### **PR-2020-004049**

SD-2023-00212 – PRELIMINARY/FINAL PLAT

REQUEST: CREATE 2 TRACTS FROM ONE EXISTING TRACT

### Planning Comments

PLAT OF
TRACTS A-2-A-1 & A-2-A-2
LAVA TRAILS SUBDIVISION
 (A REPLAT OF TRACT A-2-A,
 LAVA TRAILS SUBDIVISION)
 WITHIN THE
 TOWN OF ALBUQUERQUE GRANT
 PROJECTED SECTION 34
 TOWNSHIP 11 NORTH, RANGE 2 EAST, N.M.P.M.
 CITY OF ALBUQUERQUE
 BERNALILLO COUNTY, NEW MEXICO
 MAY, 2023

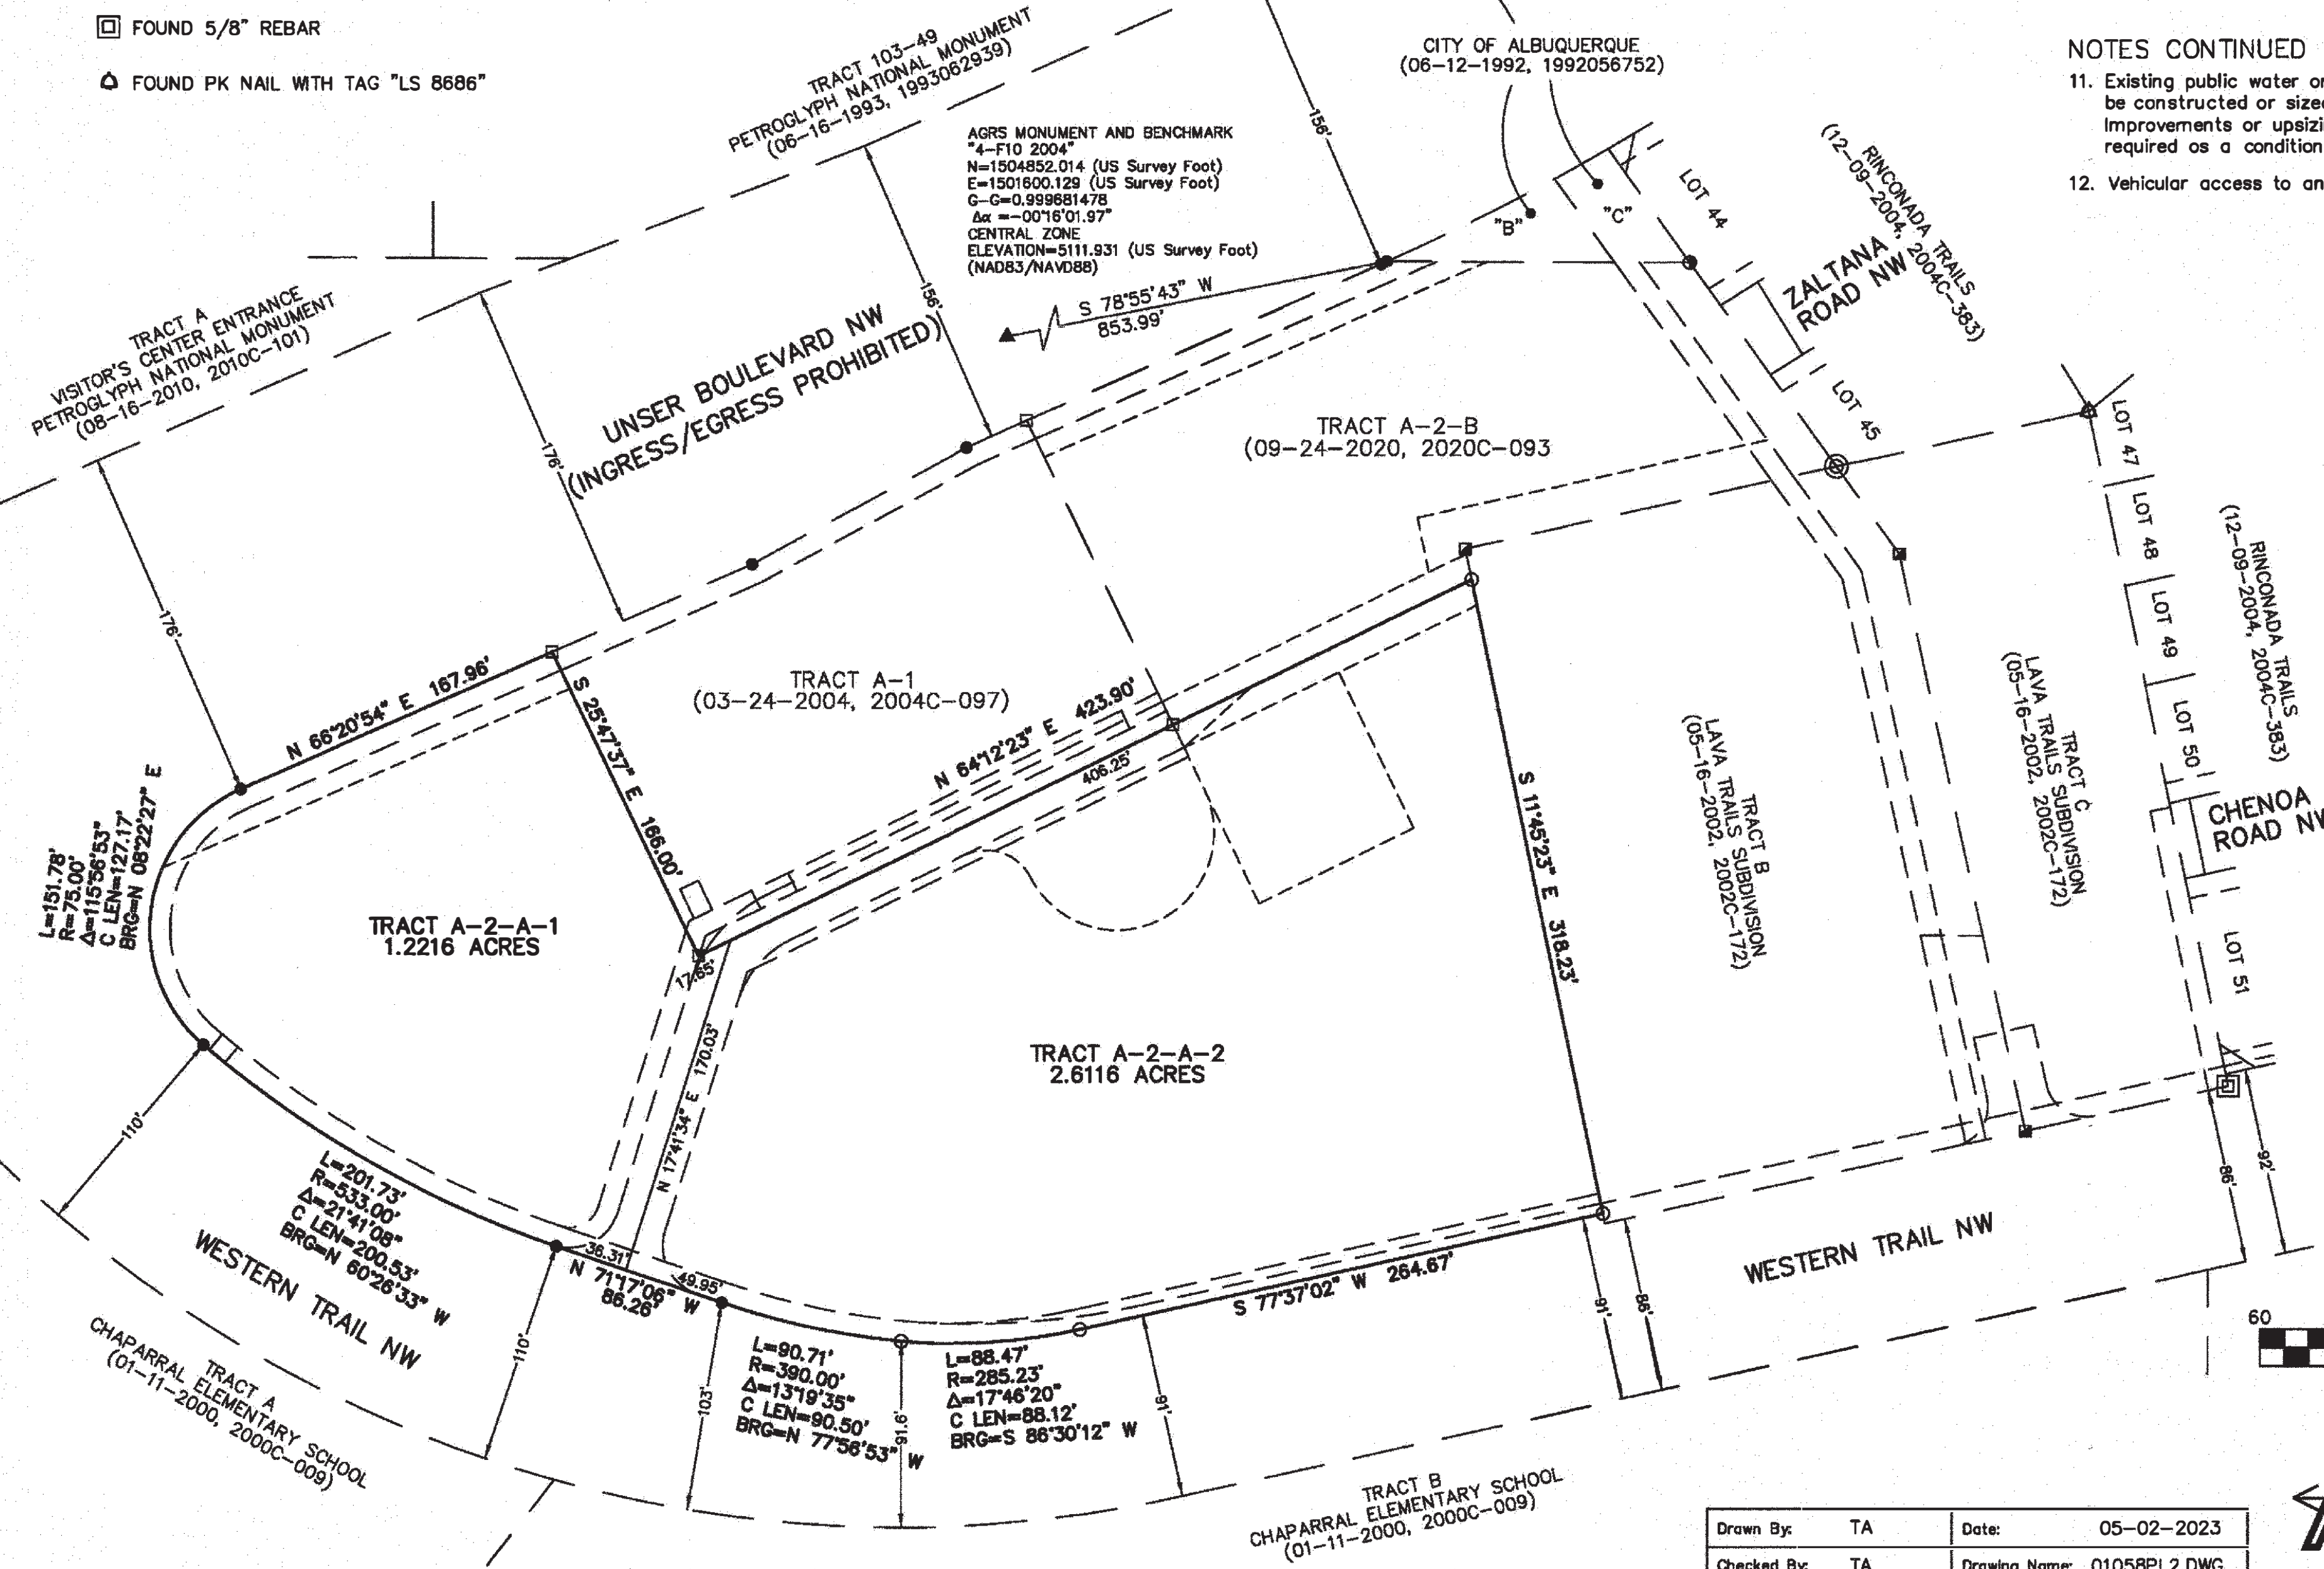
- a. When existing infrastructure is located along the property frontage(s), but plans are uncertain and no Availability Statement is being required, the following language shall be included on the plat for approval:
  - i. ***“Existing public water and/or sanitary sewer infrastructure may not be constructed or sized to adequately serve potential future development. Improvement or upsizing of existing public infrastructure may be required as a condition of future development approval.”***
- b. Add dimensions to easement #9 on both sides of the newly proposed lot line splitting the existing Tract A-2-A.

PLAT OF
 TRACTS A-2-A-1 & A-2-A-2
 LAVA TRAILS SUBDIVISION
 (A REPLAT OF TRACT A-2-A,
 LAVA TRAILS SUBDIVISION)
 WITHIN THE
 TOWN OF ALBUQUERQUE GRANT
 PROJECTED SECTION 34
 TOWNSHIP 11 NORTH, RANGE 2 EAST, N.M.P.M.
 CITY OF ALBUQUERQUE
 BERNALILLO COUNTY, NEW MEXICO
 MAY, 2023

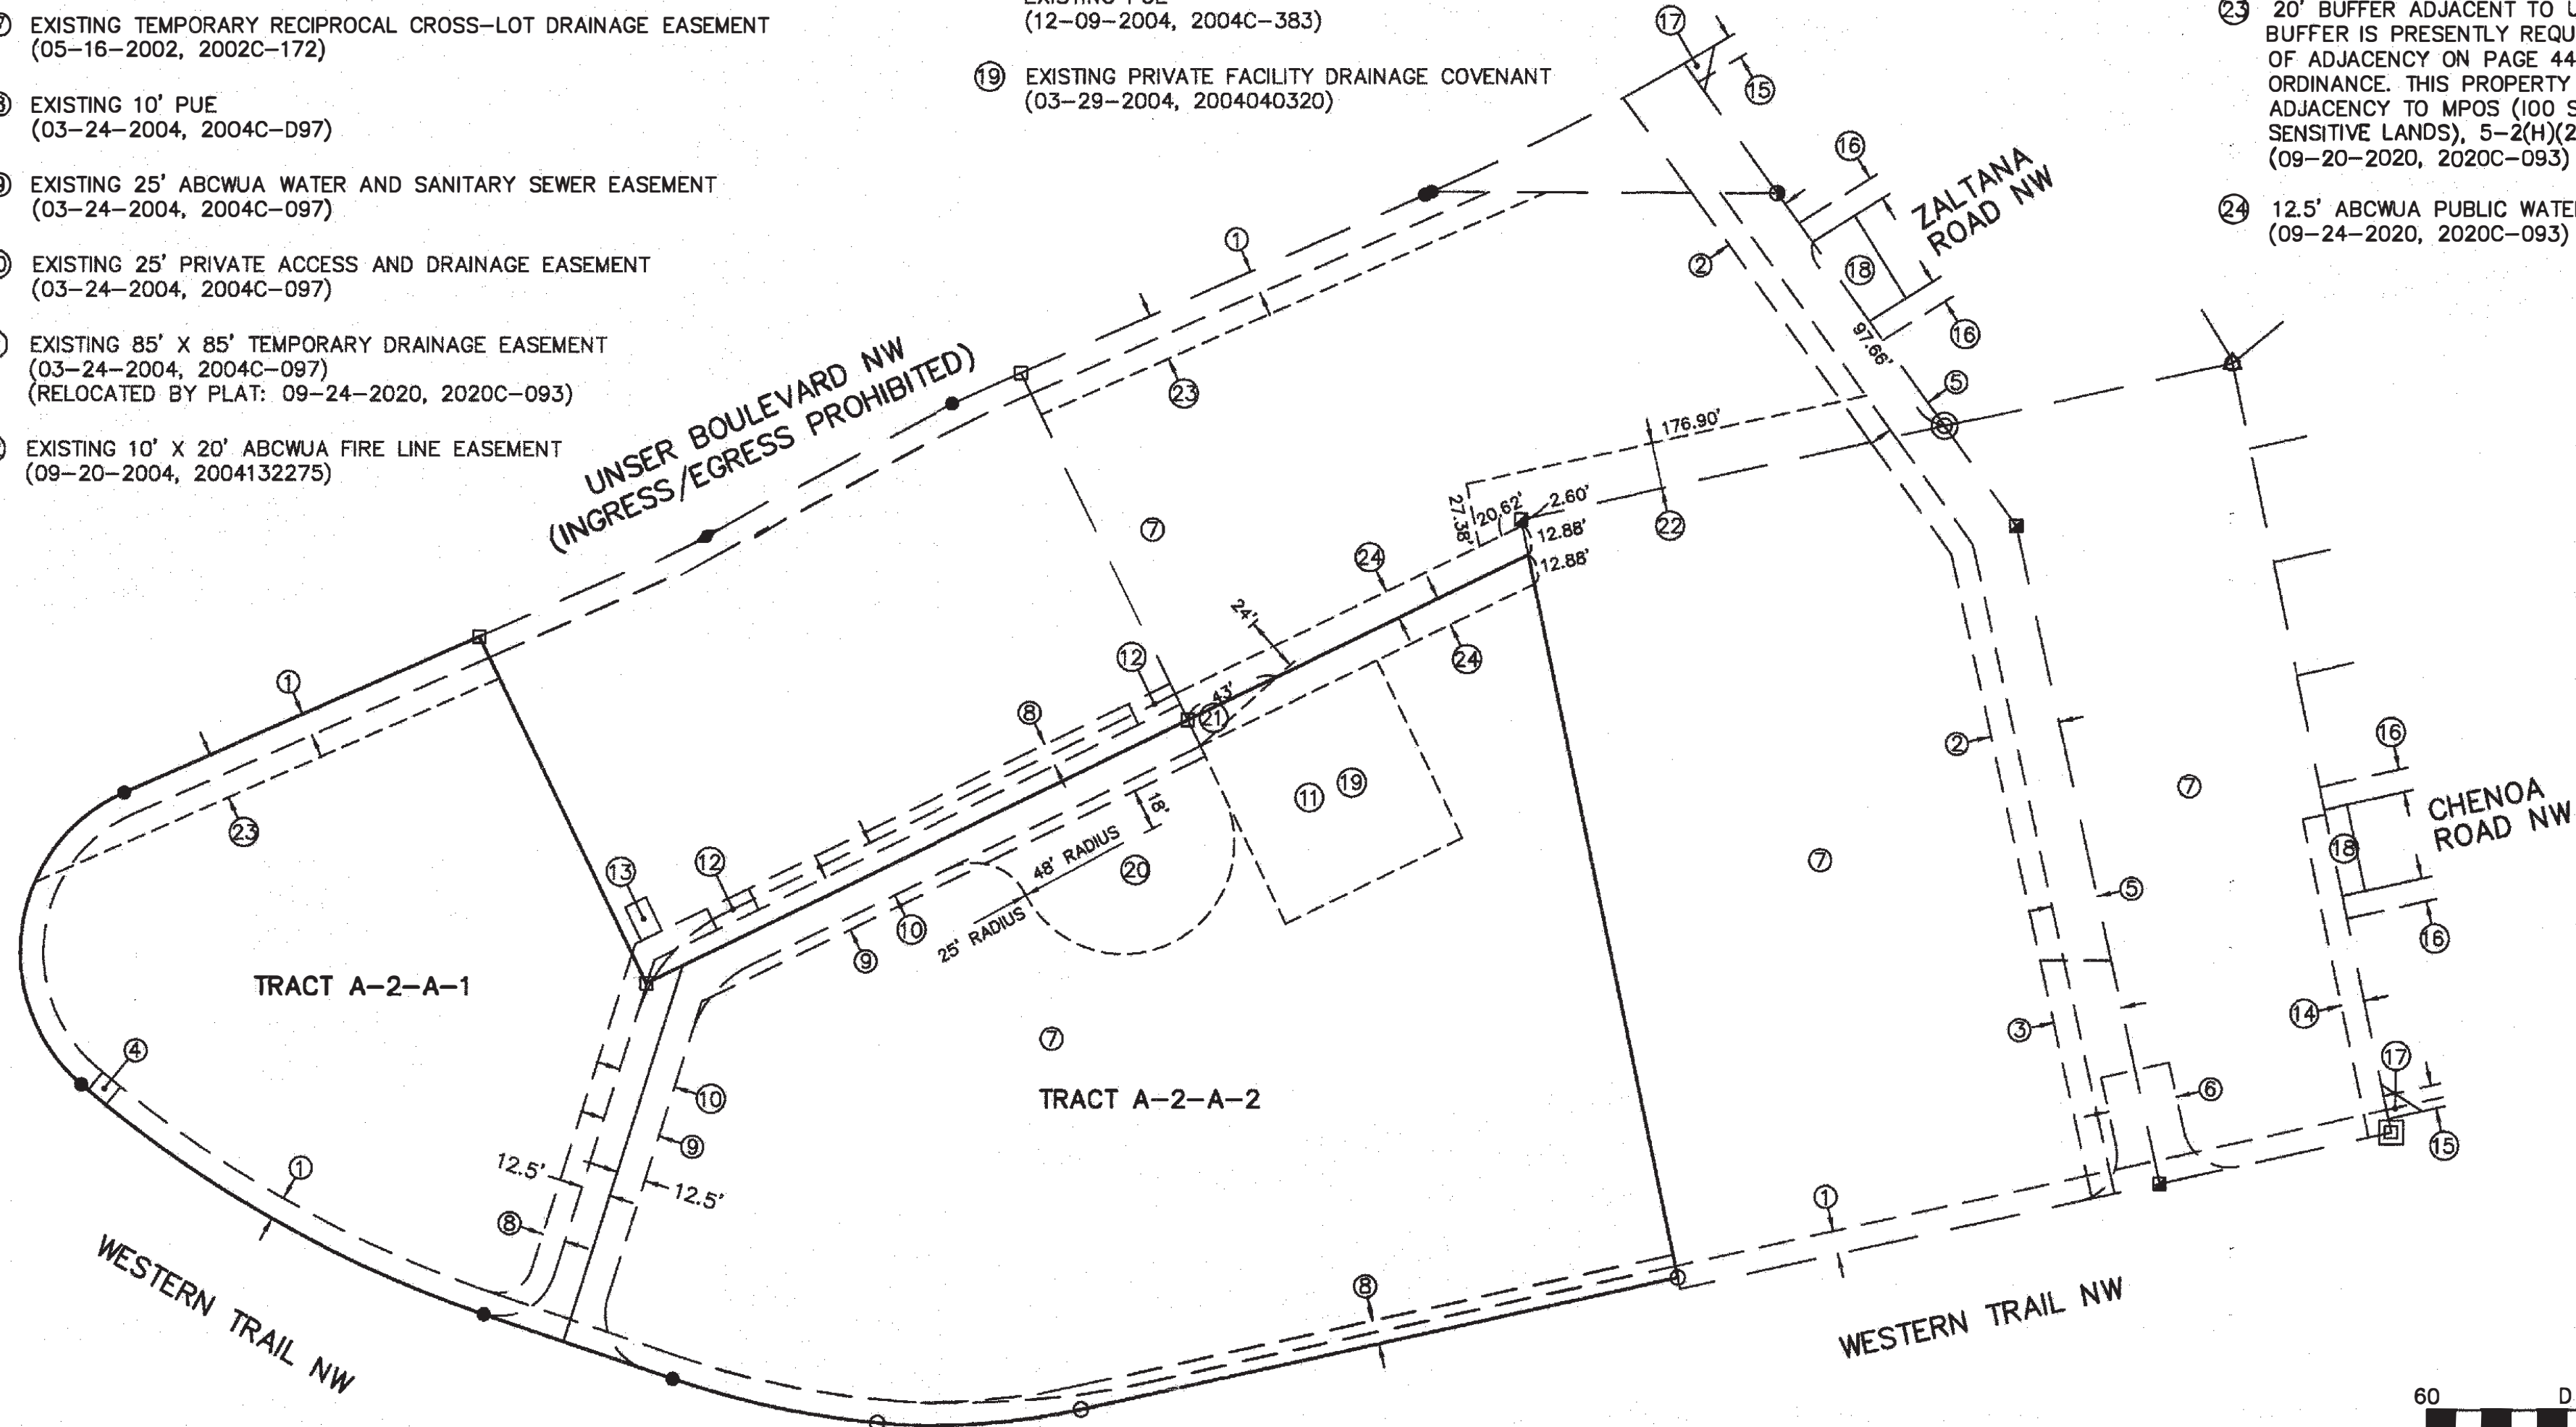
The note #23 on the plat indicates that Tract A-2-A-1 will have a 20' buffer – the line and note will need to be updated to a minimum of 45' wide for the required buffer. (This must be notated on the final plat.)
